DEVELOPMENT HEARING OFFICER

PR-2021-005714

SD-2023-00165 – PRELIMINARY/FINAL PLAT
IDO – 2022 SKETCH 7-14-21 (DRB)

REQUEST: Lot Consolidation: 8 lots into 1 lot

PLAT
OF
LOTS 1-A
MONKBRIDGE ADDITION
PROJECTED SECTION 5 T10N, R3E, N.M.P.M.
WITHIN THE TOWN OF ALBUQUERQUE GRANT
ALBUQUERQUE, BERNALILLO COUNTY, NEW MEXICO
JUNE 2021

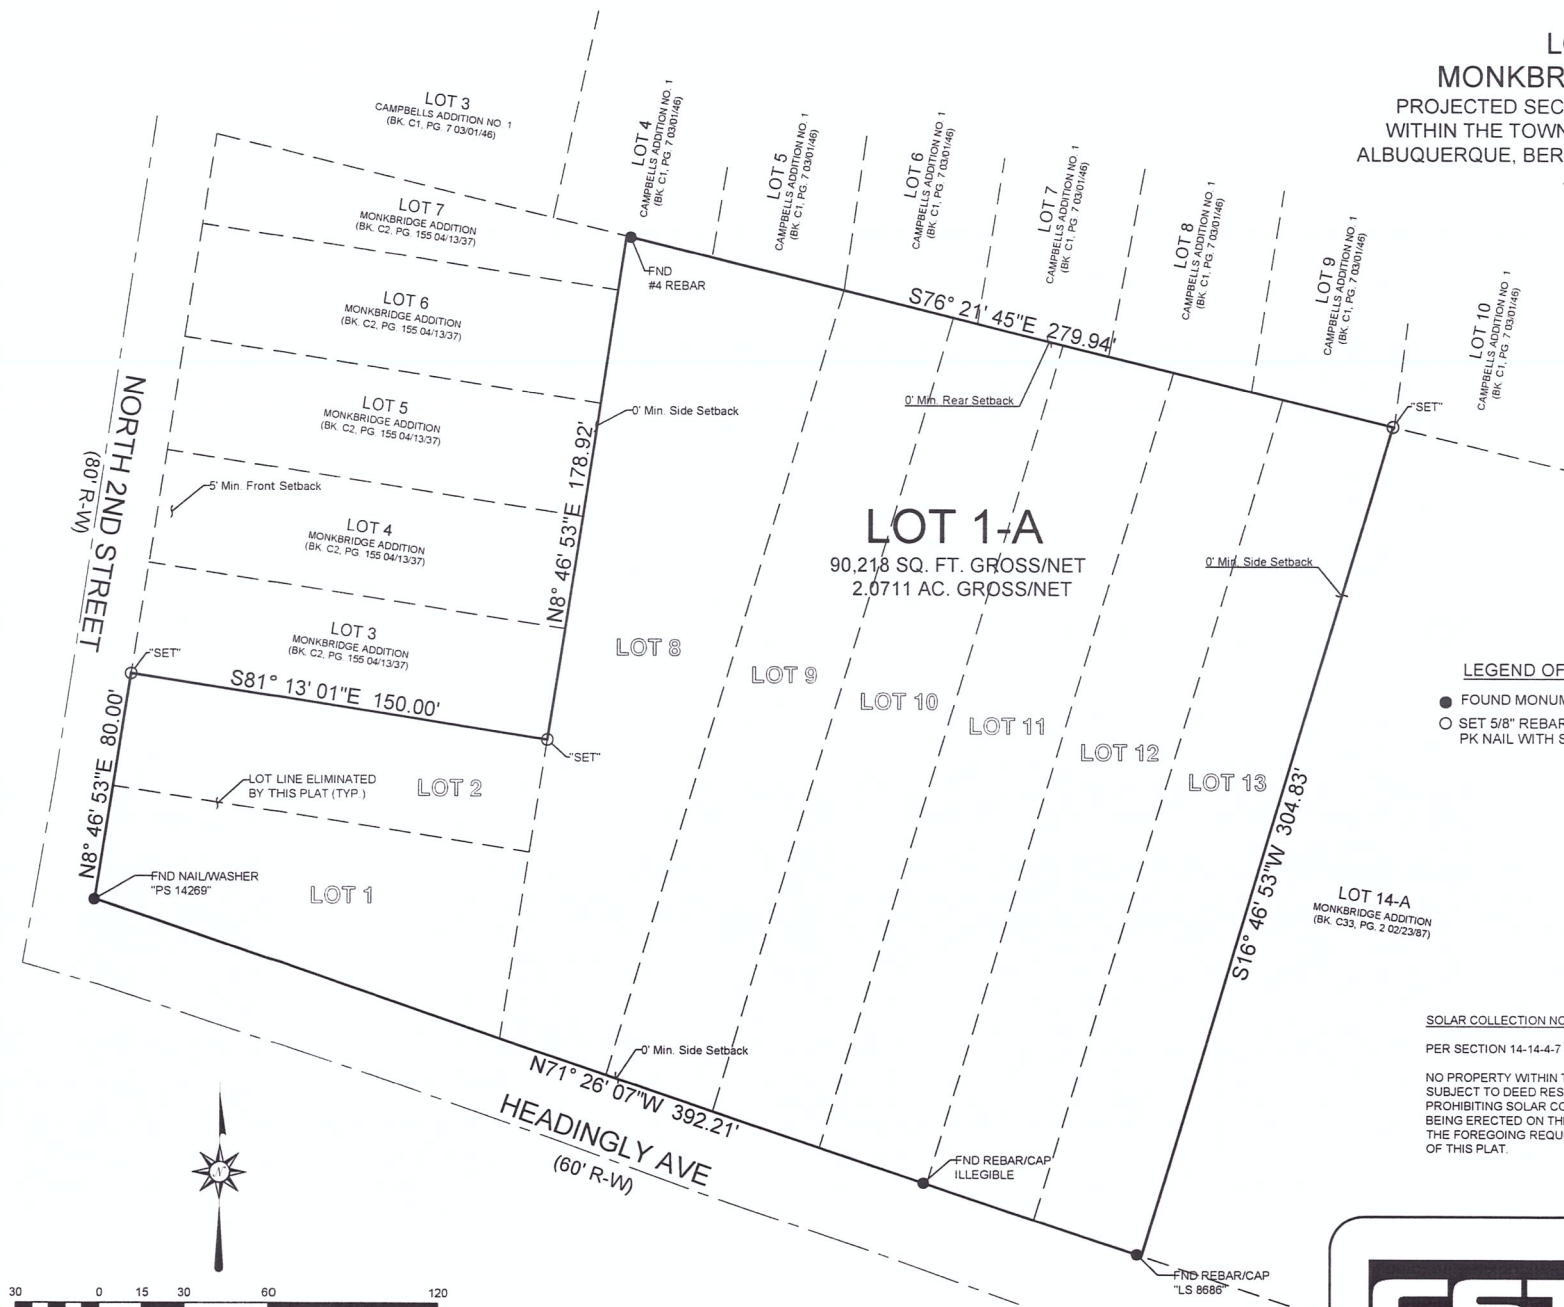
- This proposed Plat would consolidate 8 existing lots into a single lot (Lot 1-A) a total of 2.0711-acres in size.
- **Update 7/29/24:** Before the December 6, 2023 DHO meeting, the property owner provided a signed statement explaining that only a replat is being pursued at this time, per the ZEO's response. That statement is on file.

- All standards within IDO section 5-4 Subdivision of Land and 5-4(C) Compliance with Zoning Requirements apply to platting actions.
- *Confirm that no new nonconformities will be created with replat.**

- DXF approval from AGIS must be obtained. The application number must be added to the Plat.
- Once/if the plat is approved by the DHO, the date of DHO approval must be added to the plat prior to final sign-off of the plat.
